Assistant Director Planning & Economic
Regeneration,
Arun Civic Centre,
Littlehampton,
BN17 5LF

re LU/78/13 East Beach, Littlehampton

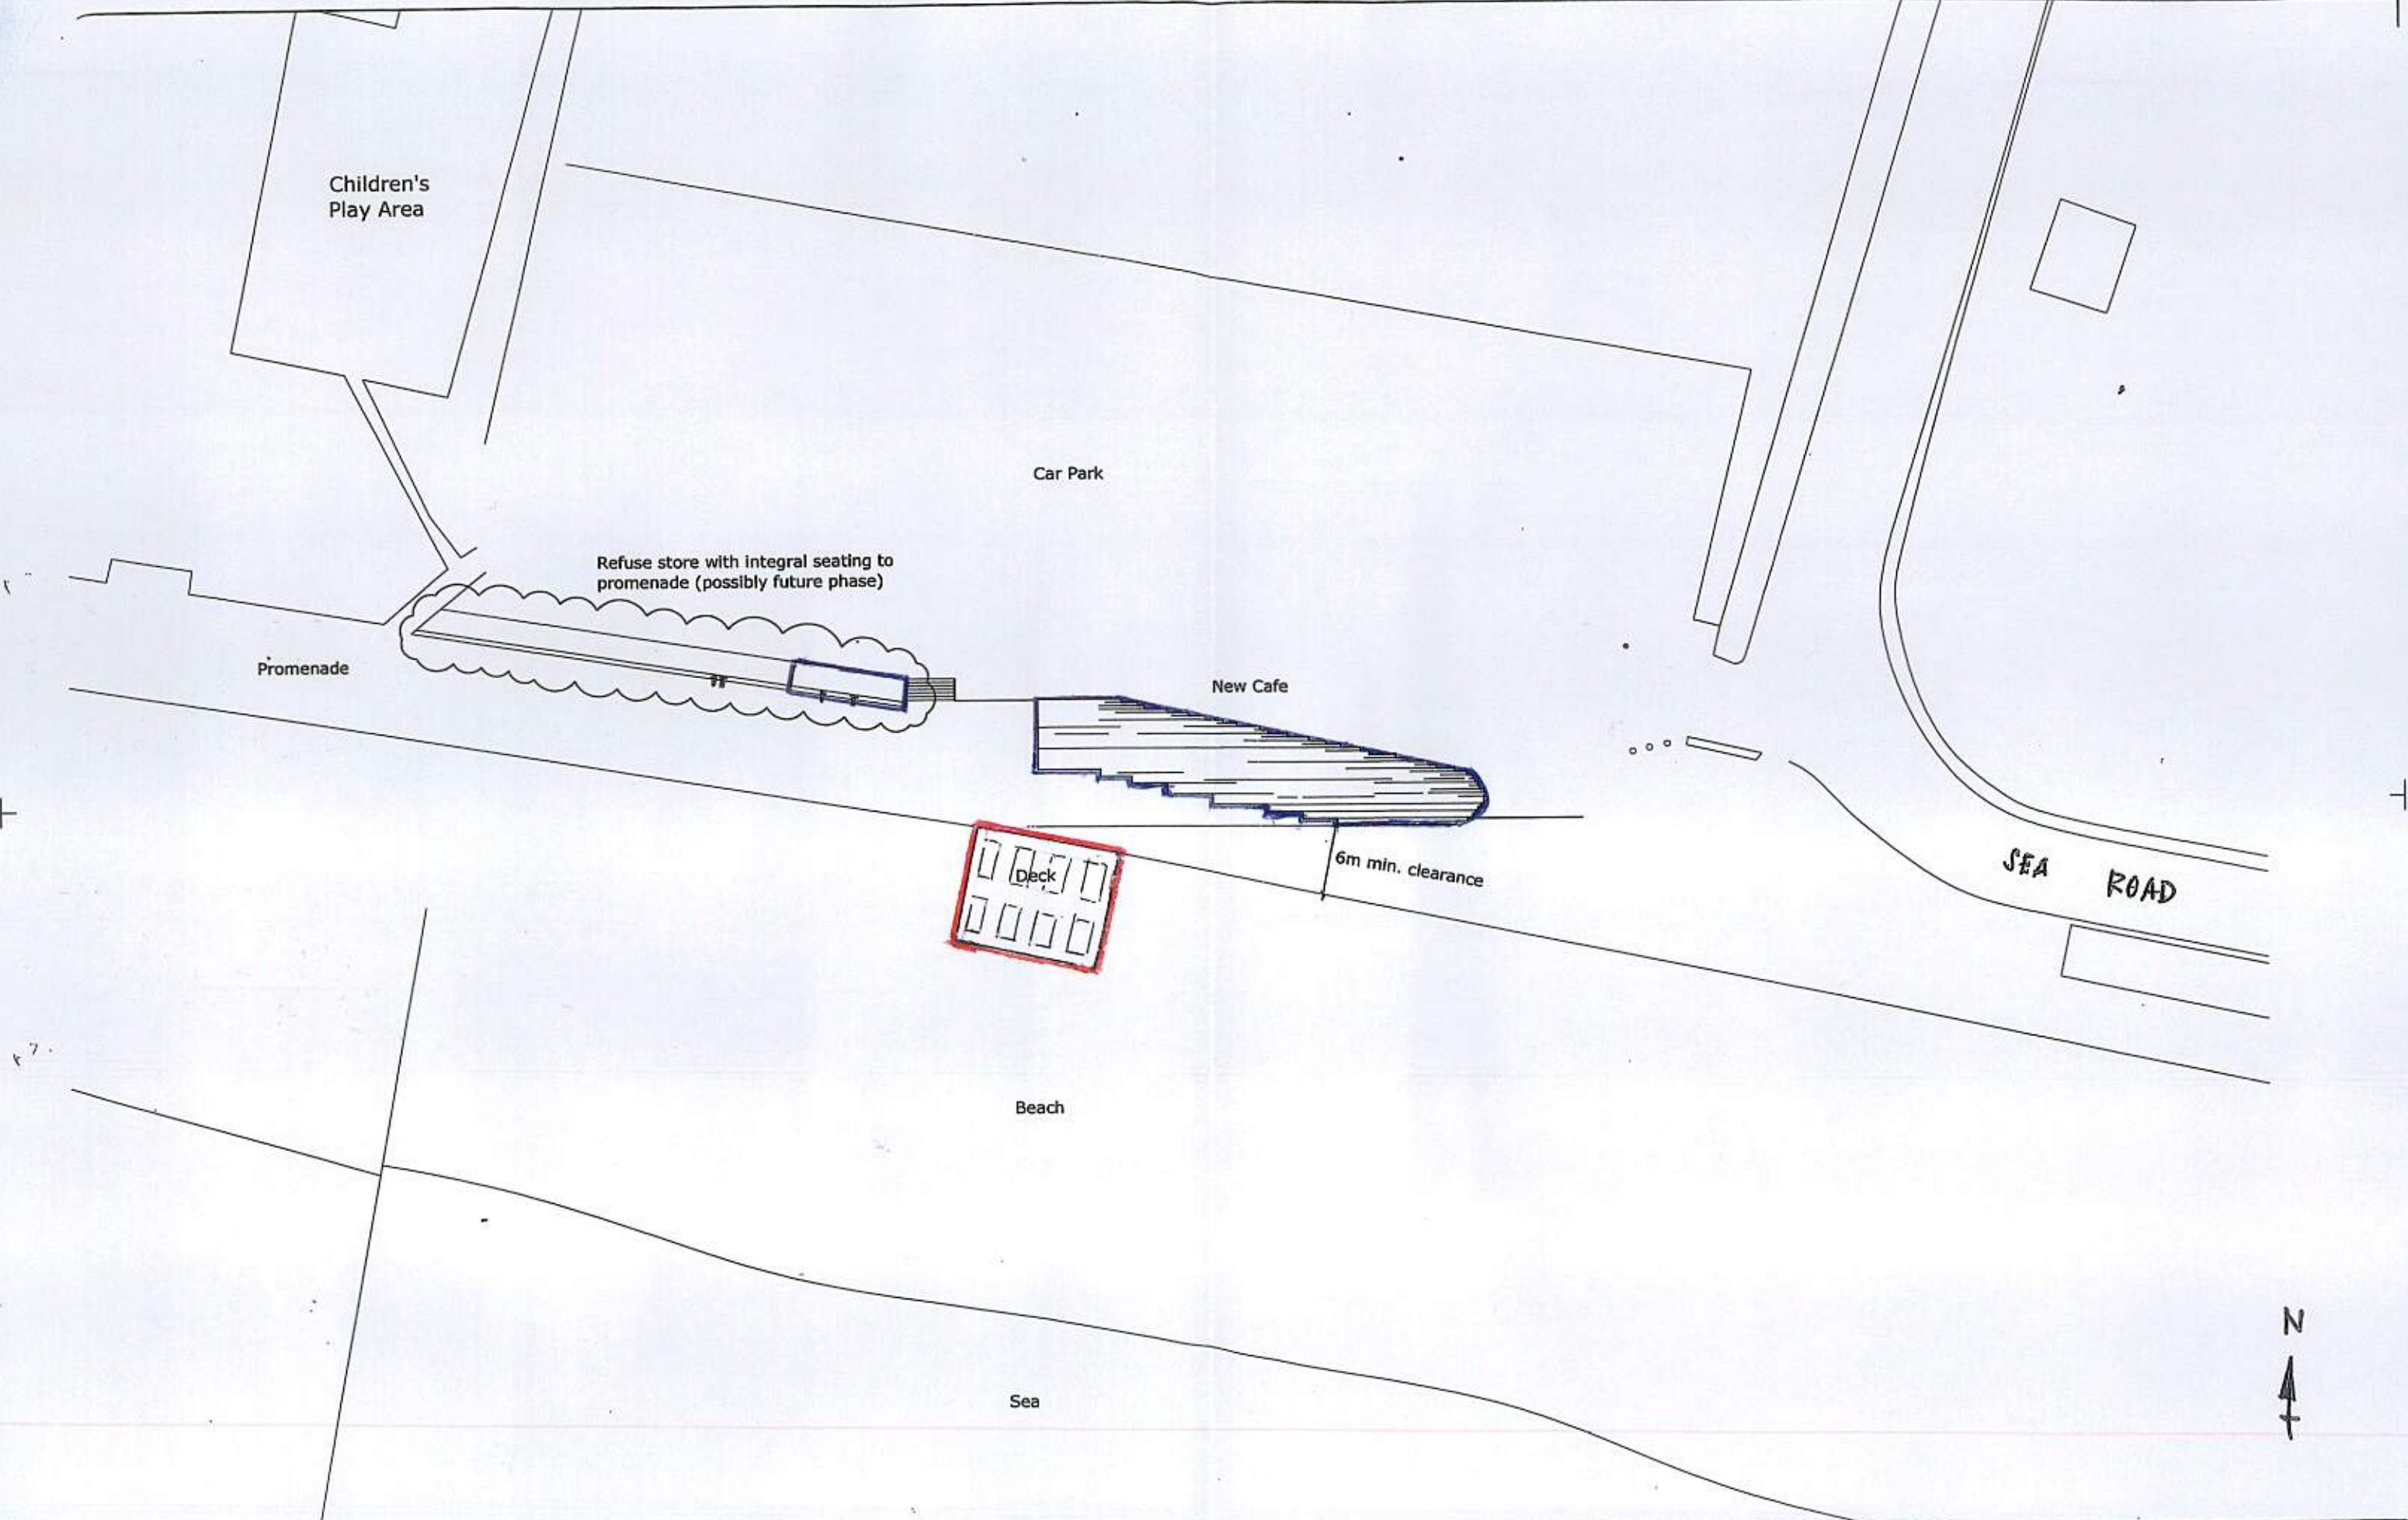
I wish to repeat my objection to this development when the decking was originally installed, i.e. it appears to reduce the area of the beach to which the public has unrestricted access.

EAST BEACH CAFE
DECKING - PICNIC TABLES
SCALE 1:50

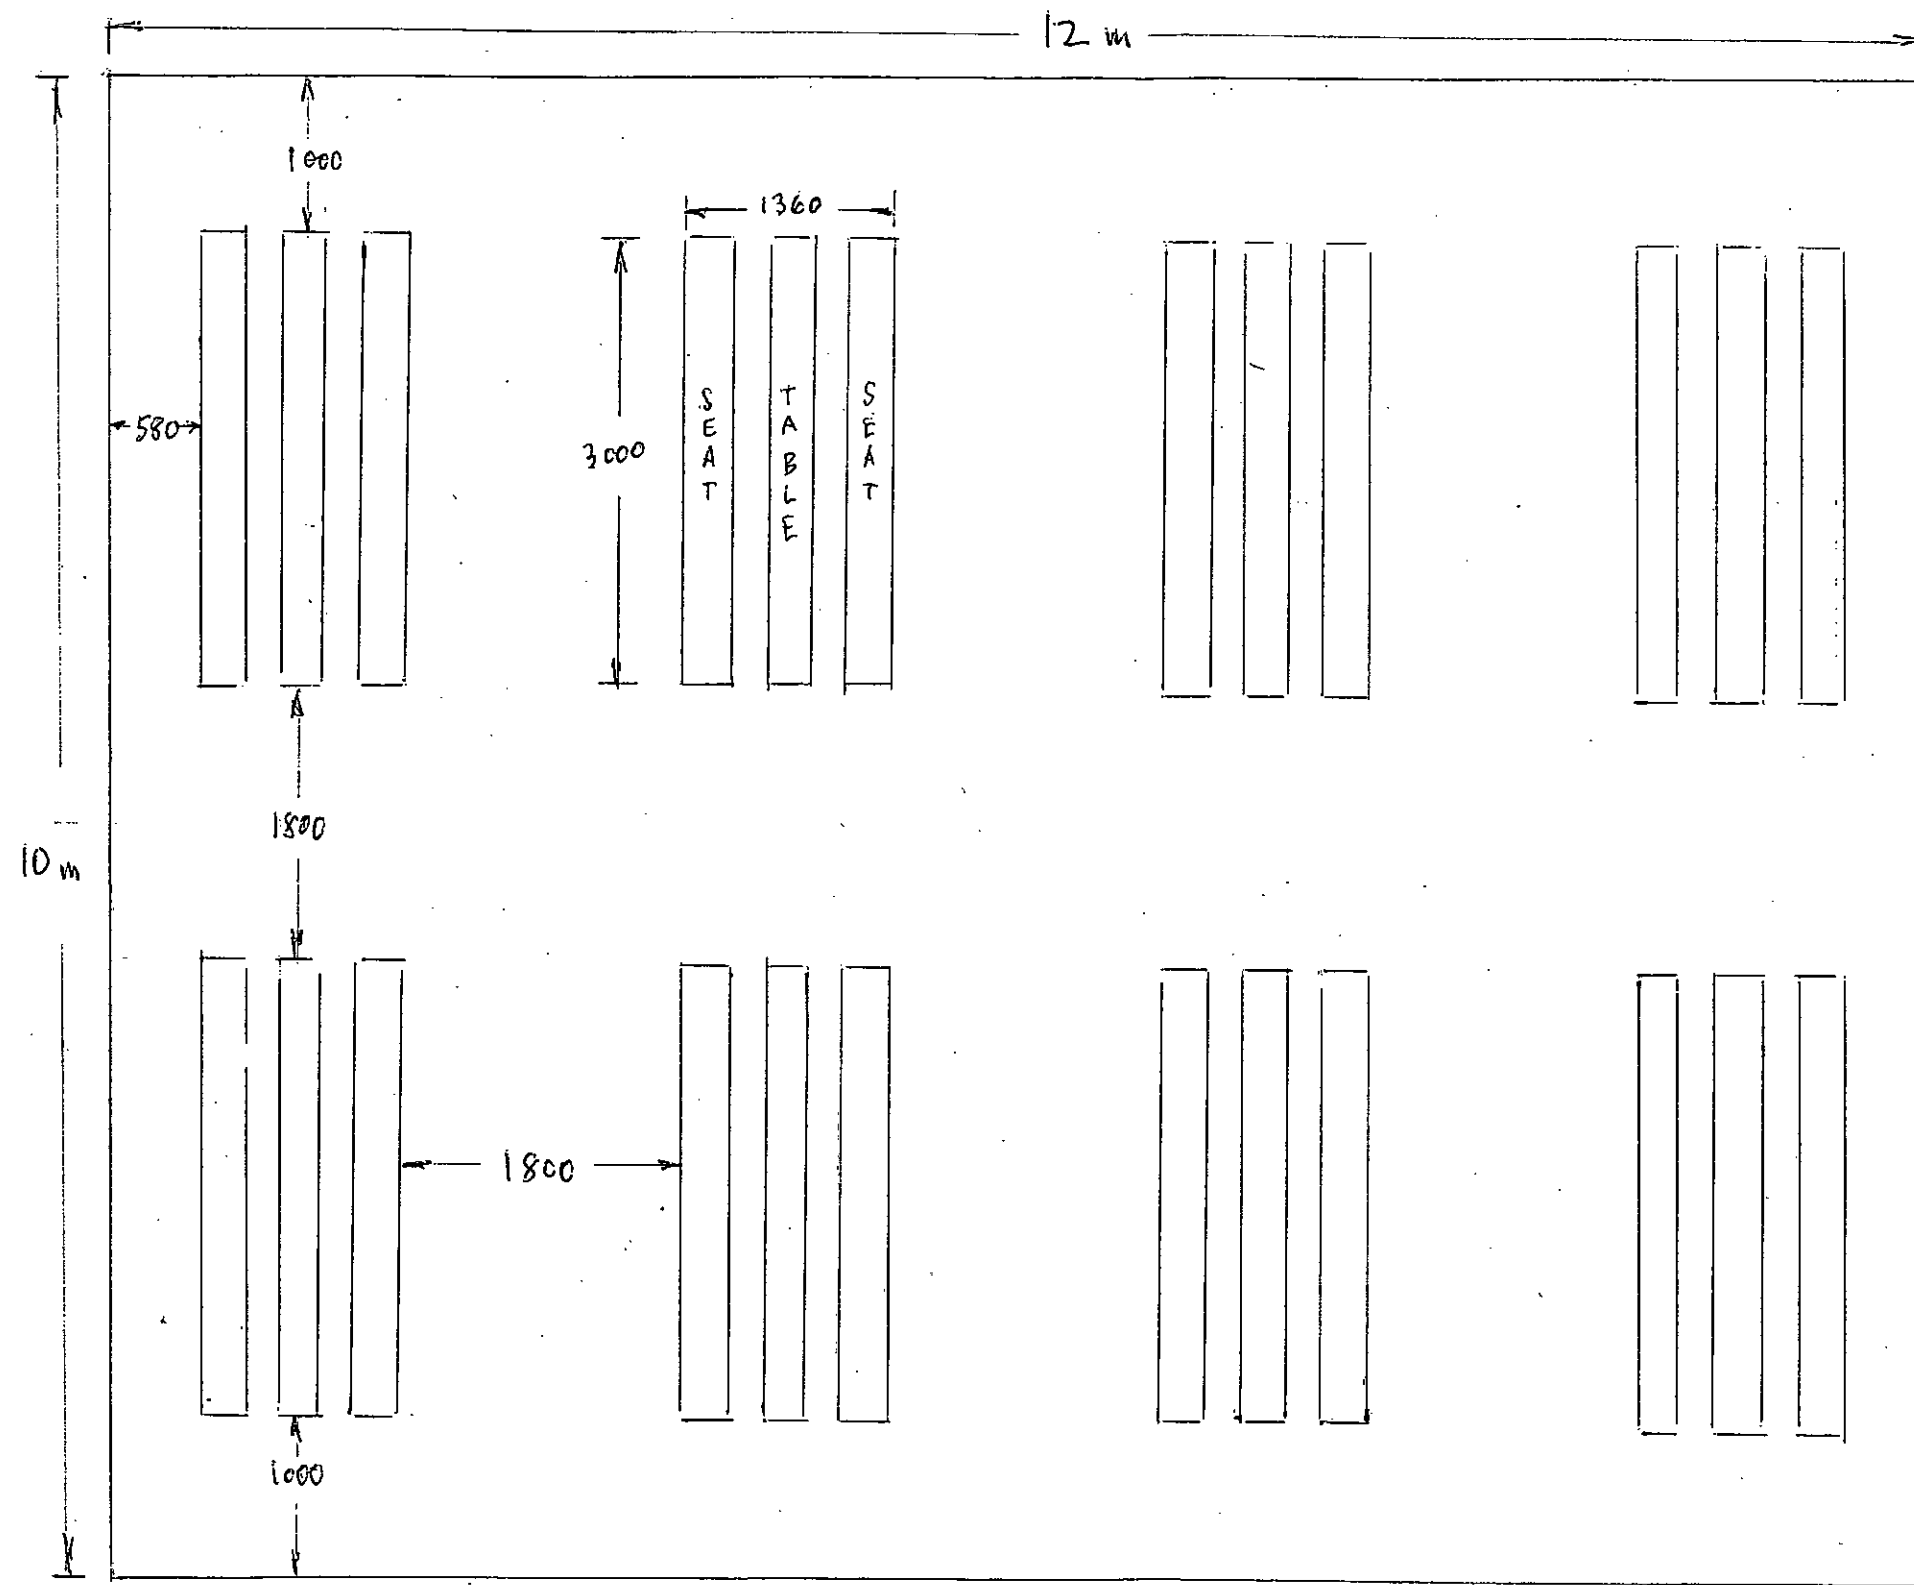
Furthermore, the design of the proposed new furniture which, apparently is to be permanently fixed, is quite out of keeping with its surroundings!
